Phone: 0300 123 6780
Email: developeras@lancashire.gov.uk
Your ref: 3/2026/0265
Our ref: 3/2026/0265/HDC/KW
Date: 03 July 2026

Location: 1 Dewhurst Farm Holiday Let Longsight Road Langho BB6 8AD
Proposal: Change of use from holiday let to C3 dwelling with unrestricted residential use.
Grid Ref: 368777 434022

Summary

Title: Highway Plan.

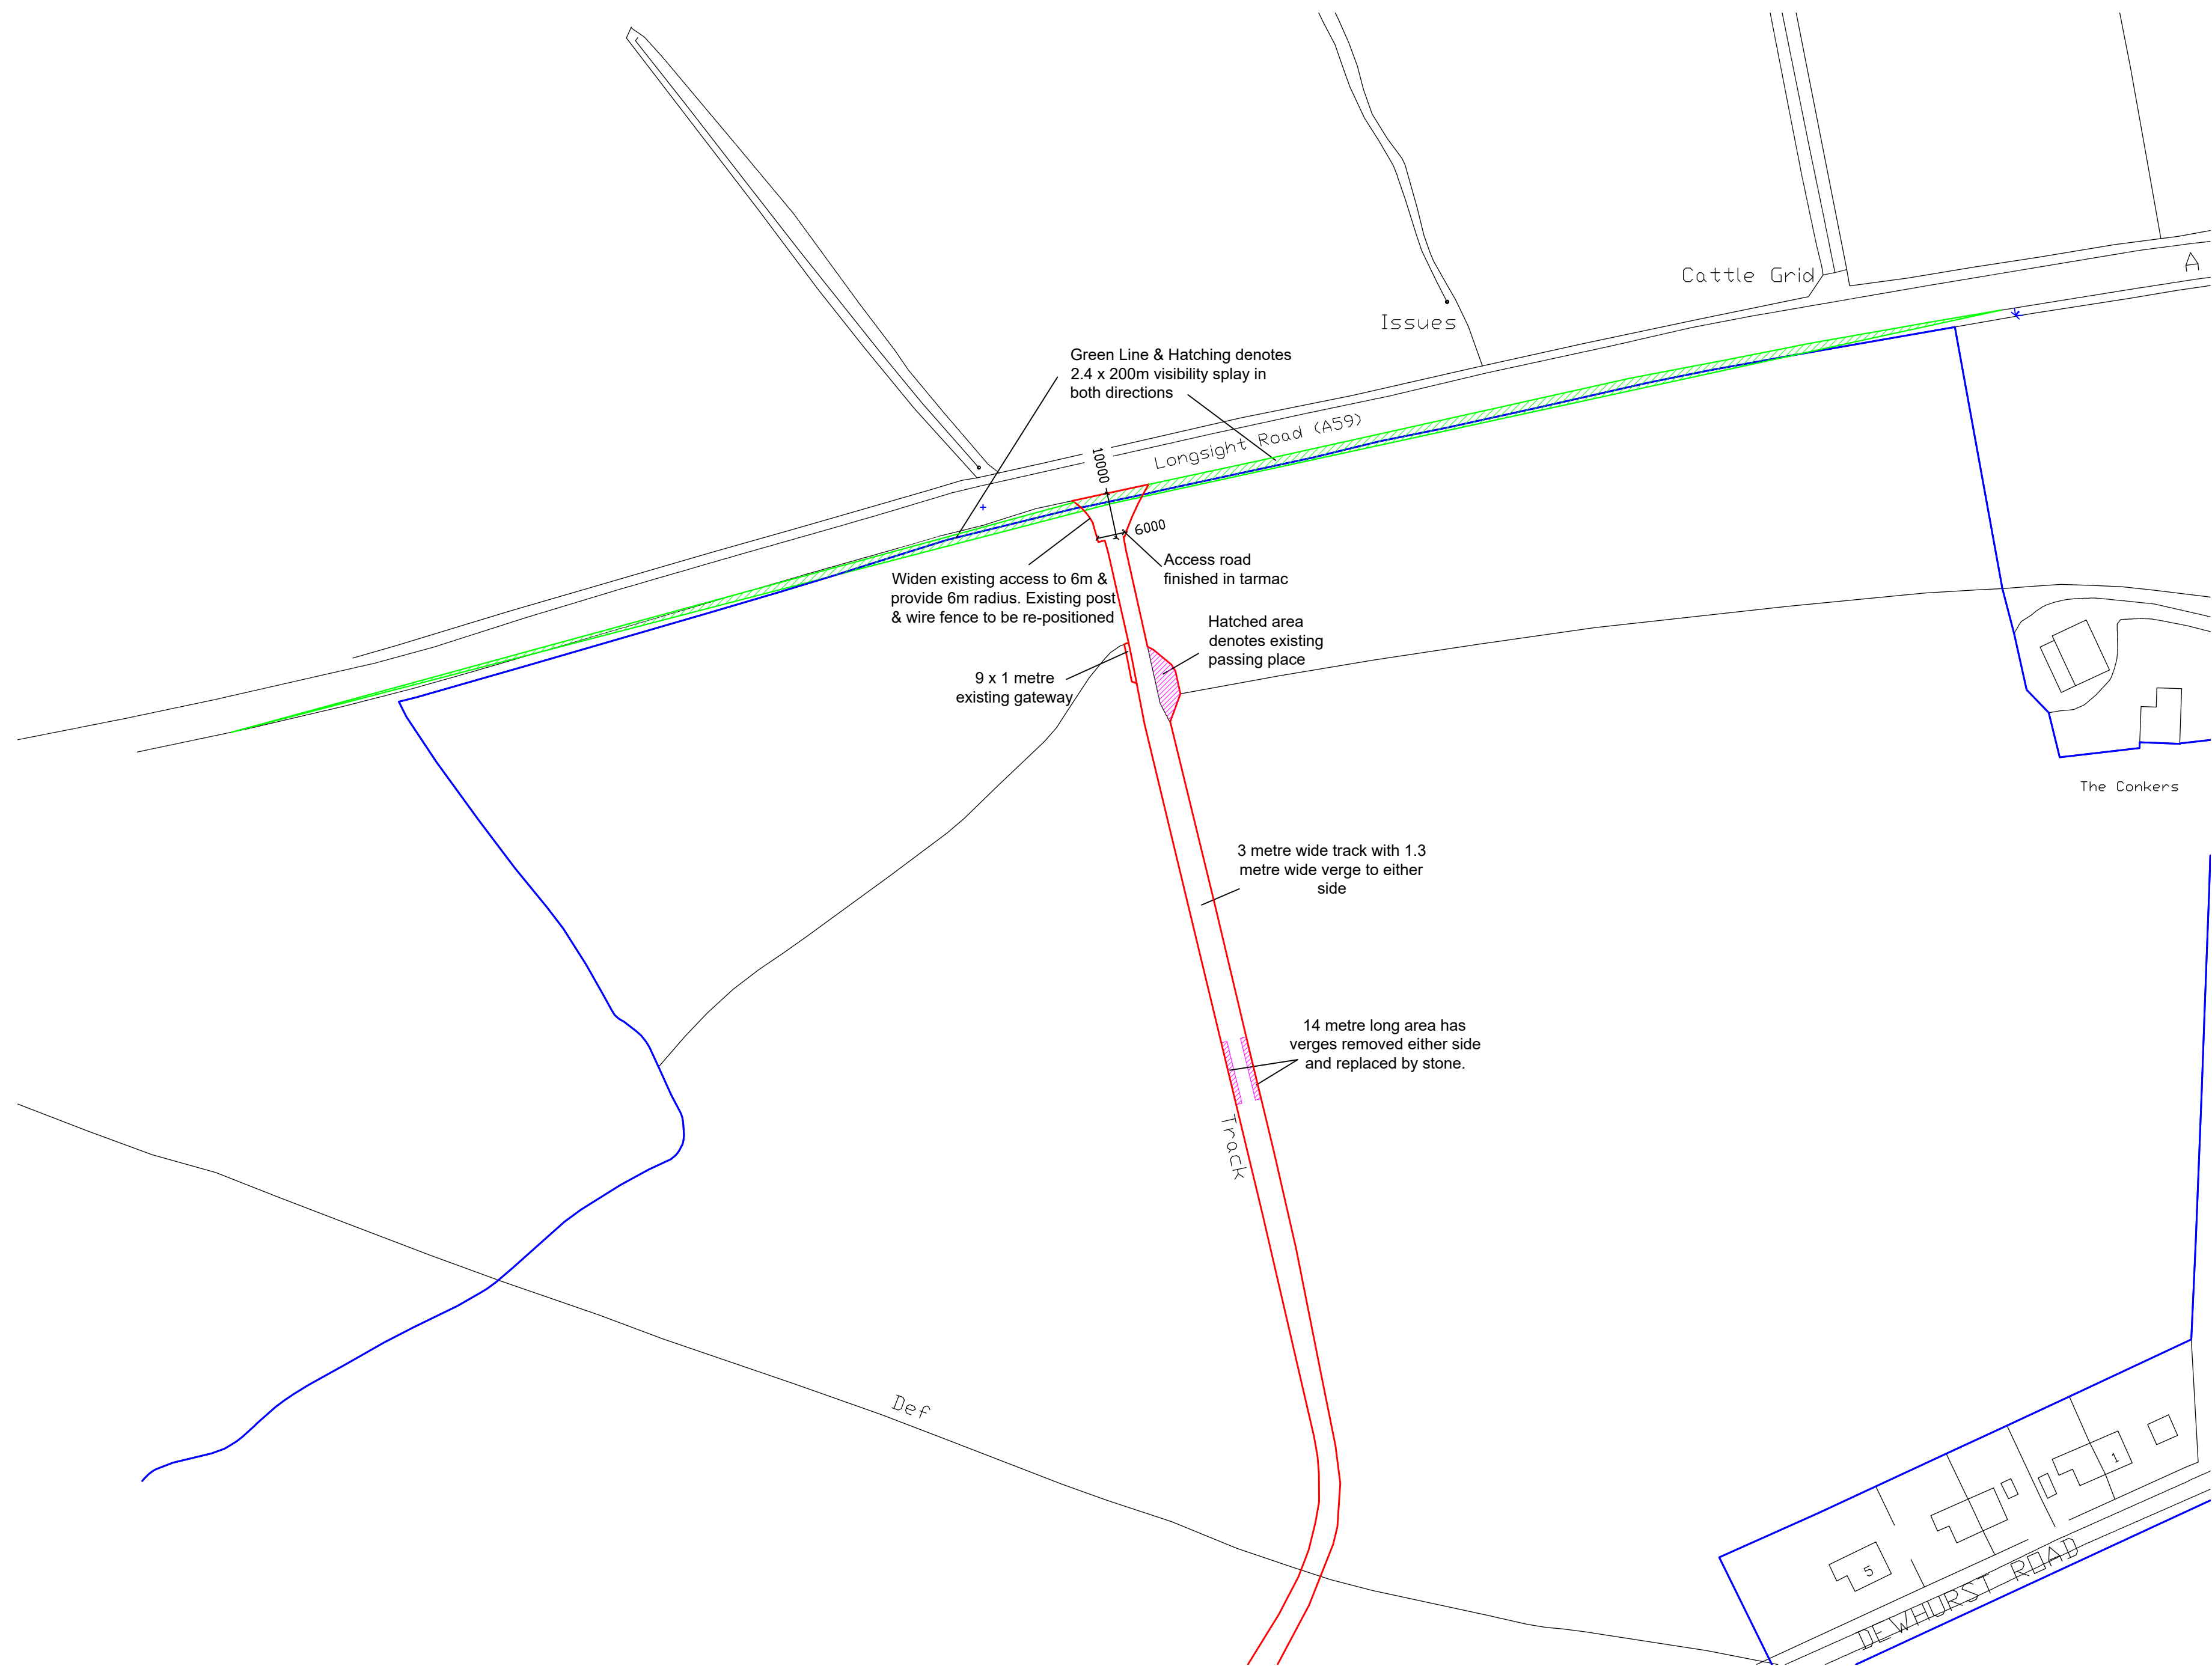
The site will continue to utilise an existing access from Longsight Road which is an A classified road, subject to a national speed limit. The access leads to a private access track before entering the parking area. The access track currently serves numerous dwellings, holiday lets and Public Footpath FP0346006.

The LHA are aware that improvements to the access and the track have already been made following application reference 3/2019/0076. The LHA do not anticipate a significant intensification of use of the private access track or the access and as such, is satisfied with the existing arrangements, approved under the previous application.
